**April 2, 2014
DRB Comments**

PROJECT # 1002202

APPLICATION # 14-70073/ 10074

RE: Tract L-1-B-1, Panorama Heights

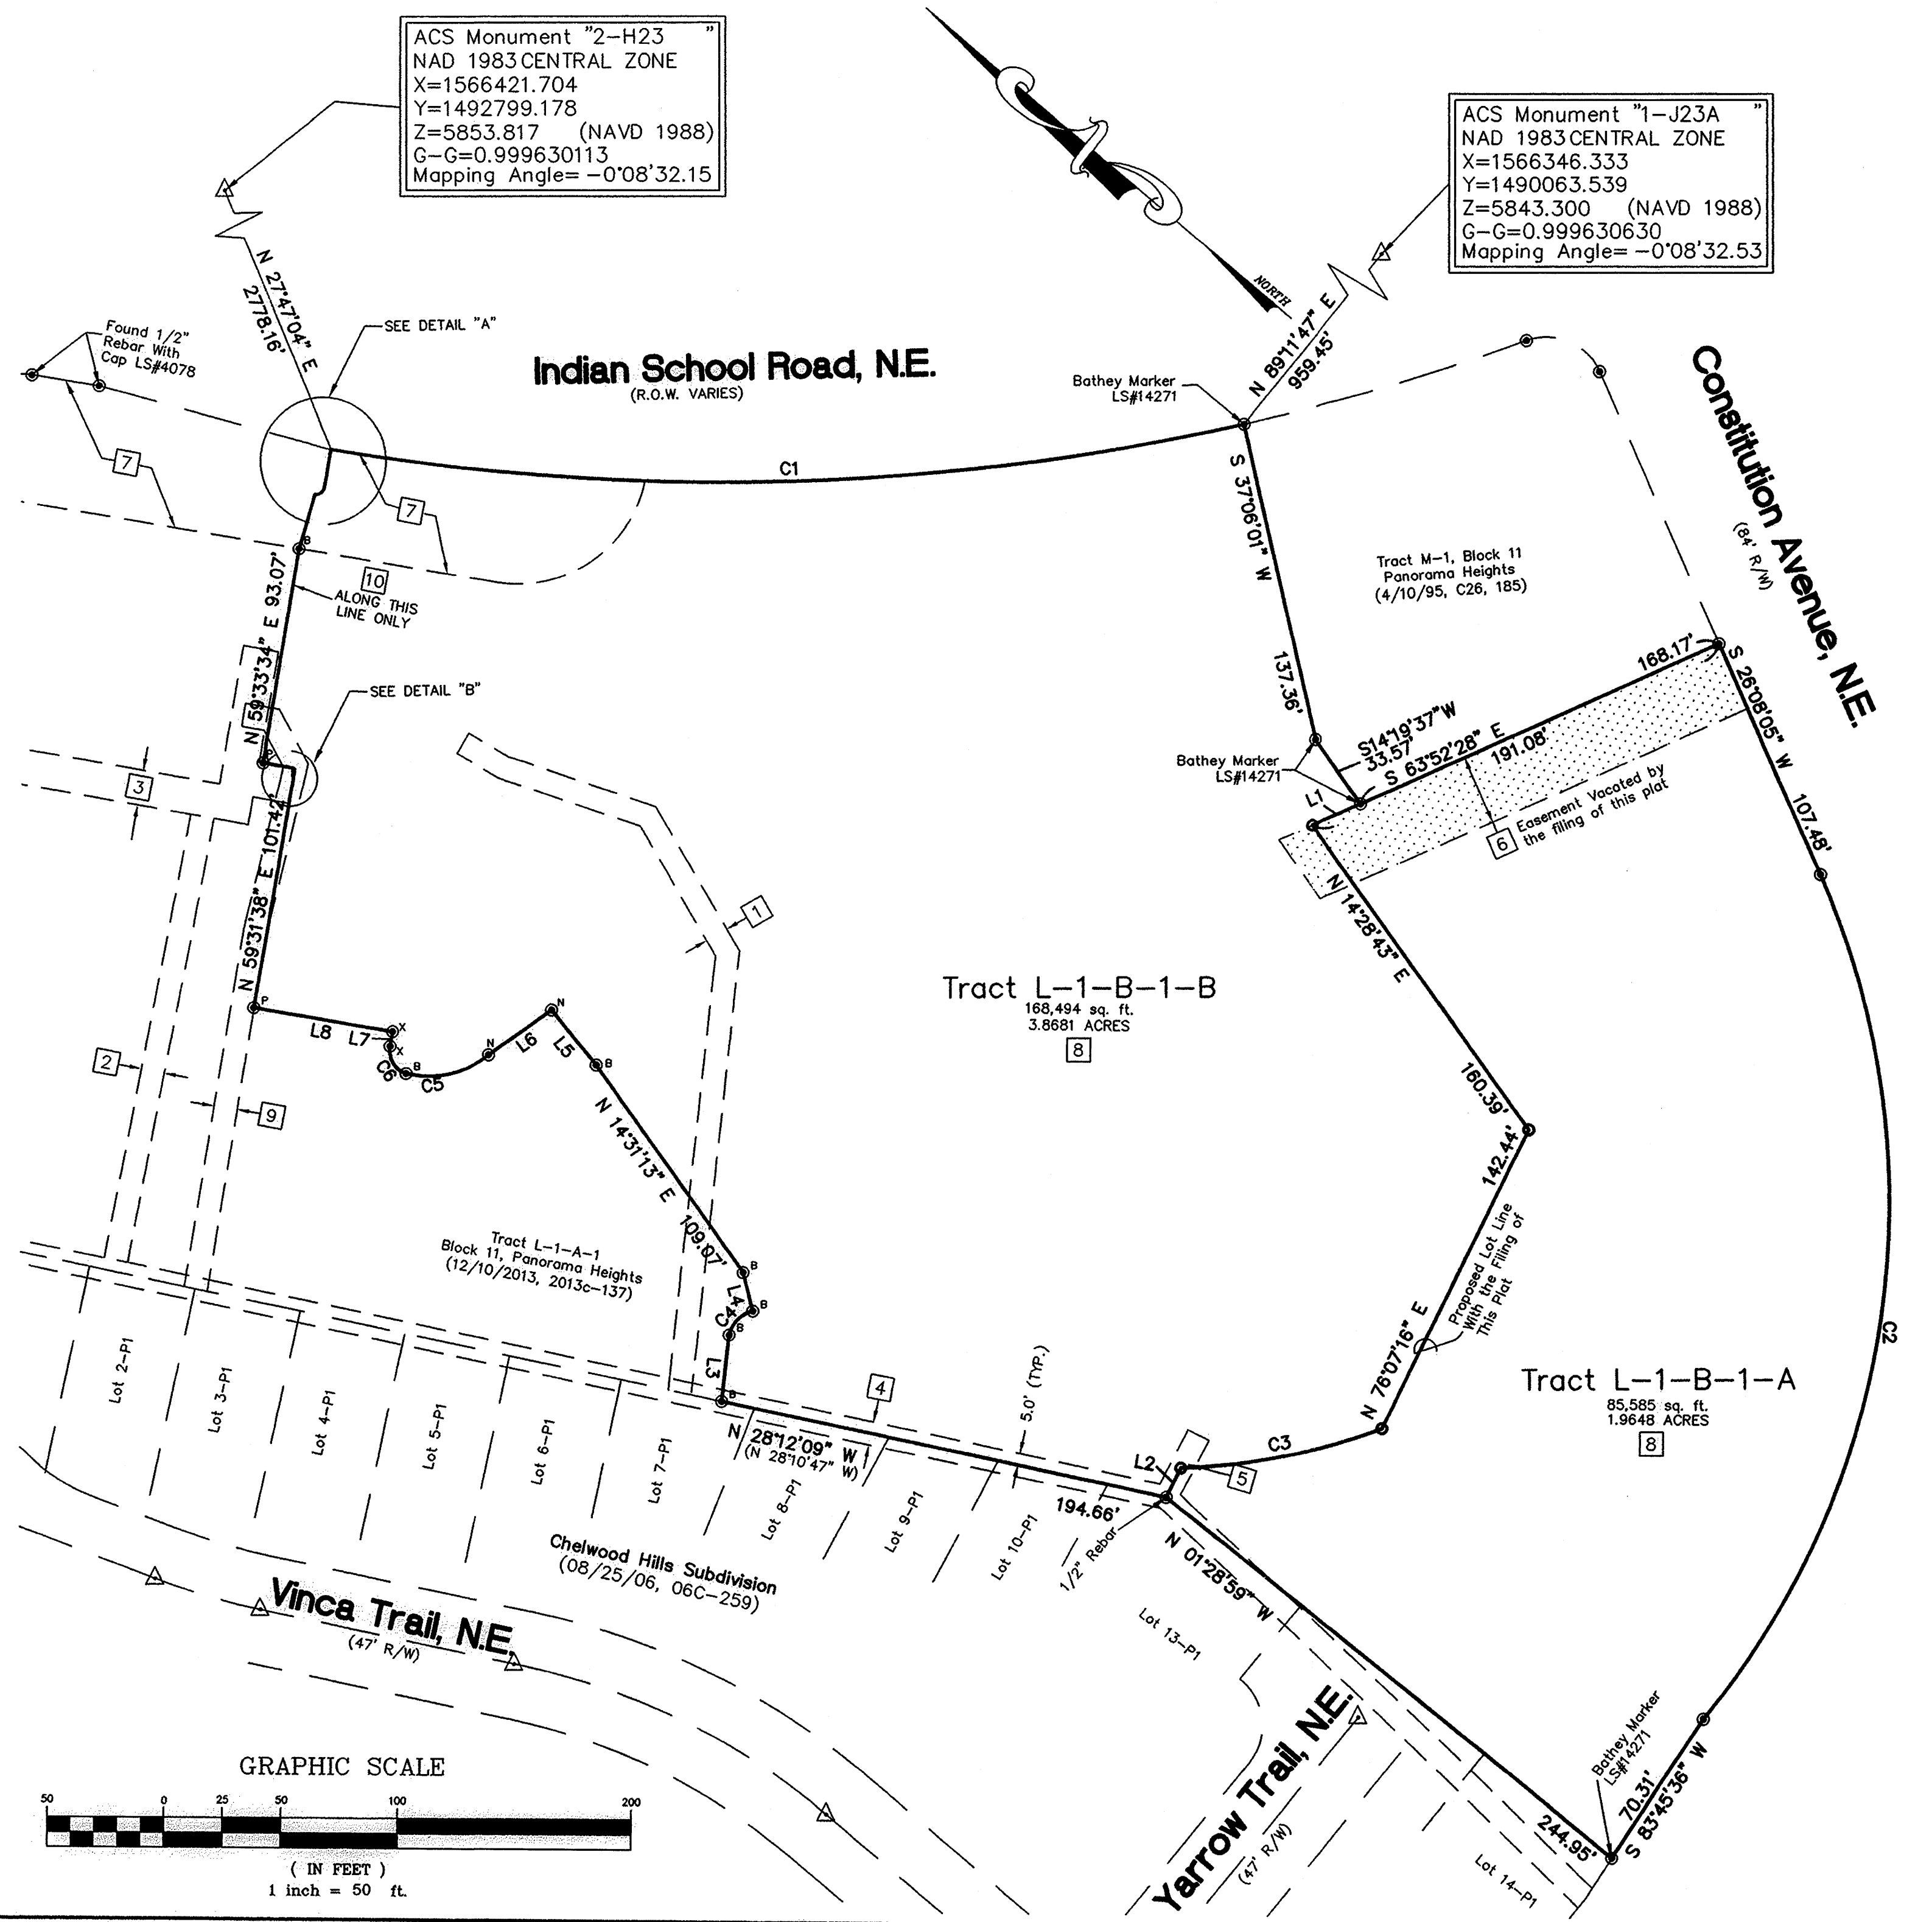
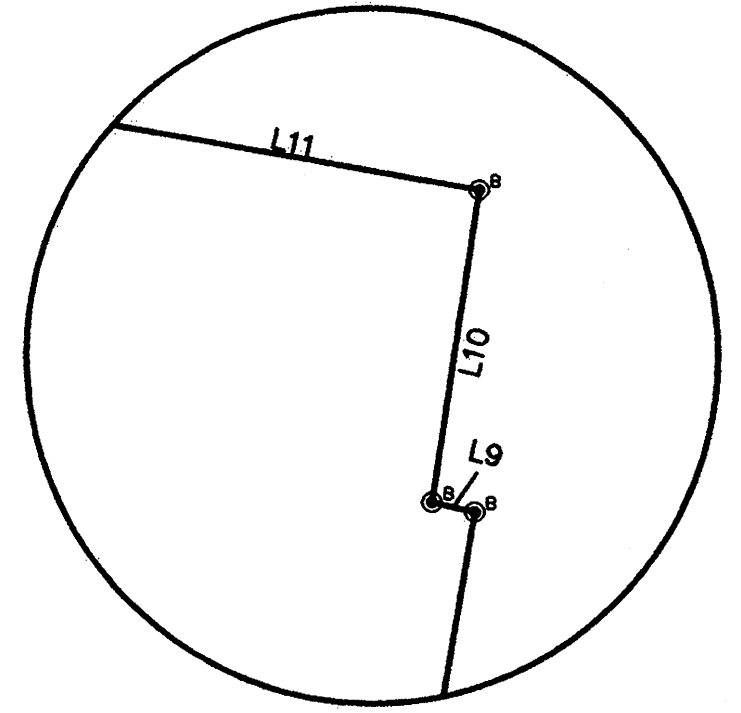
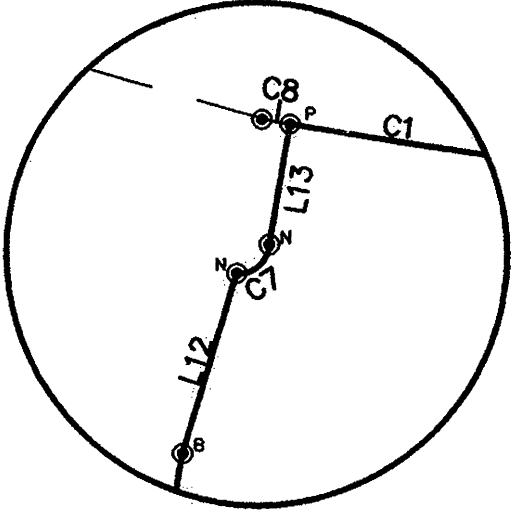
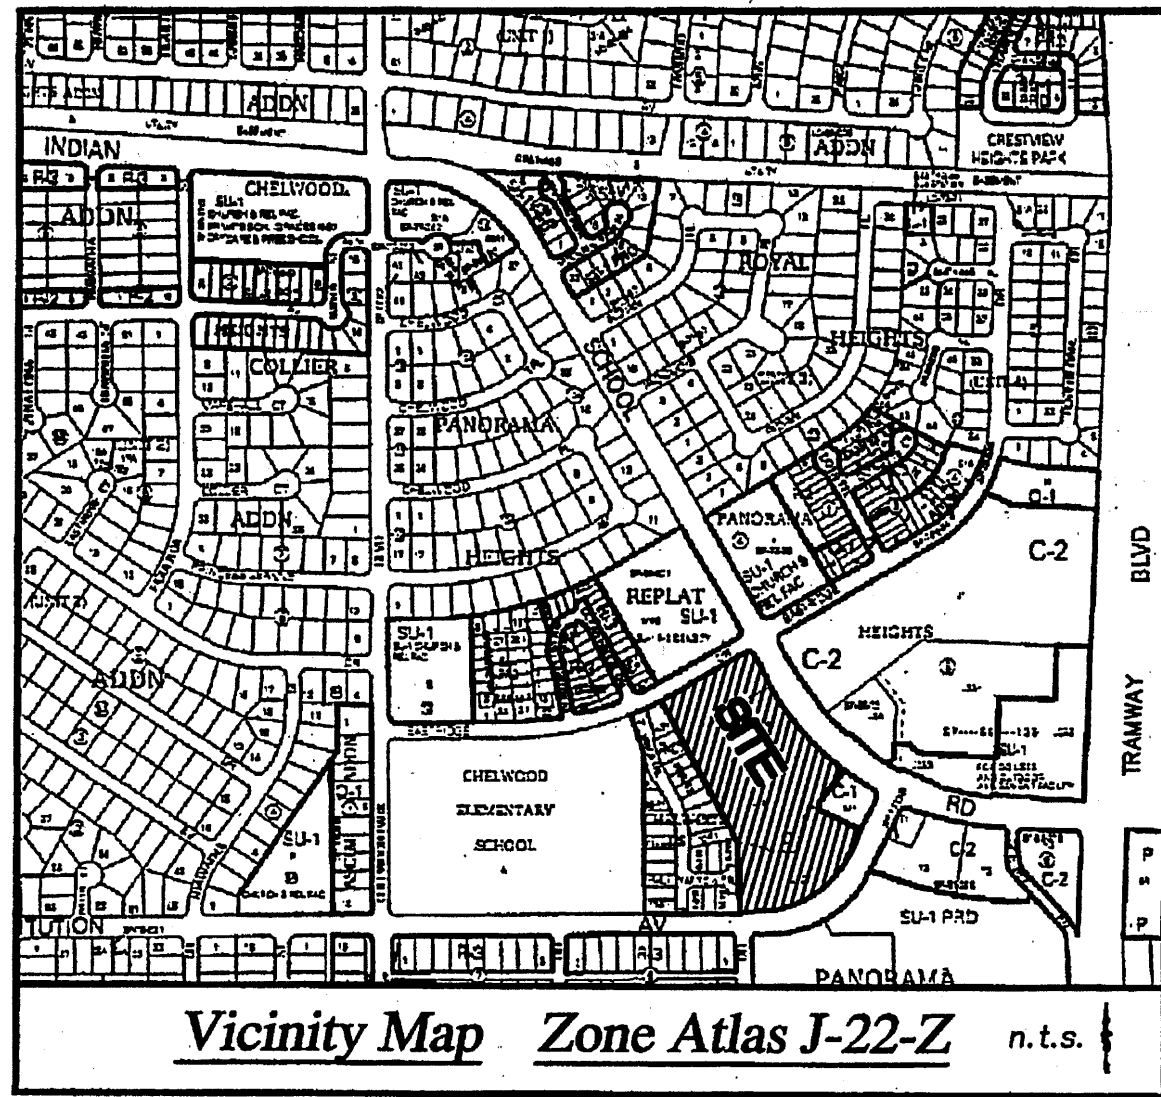
Significant site alterations, additional easements, or a revised lot layout are needed for the parking lot to conform to proposed lot line; parking lot aisles and landscaping need to be on-site or within an easement.

Easement Note 11 is not valid, as Tract M-1 is not a part of this plat.
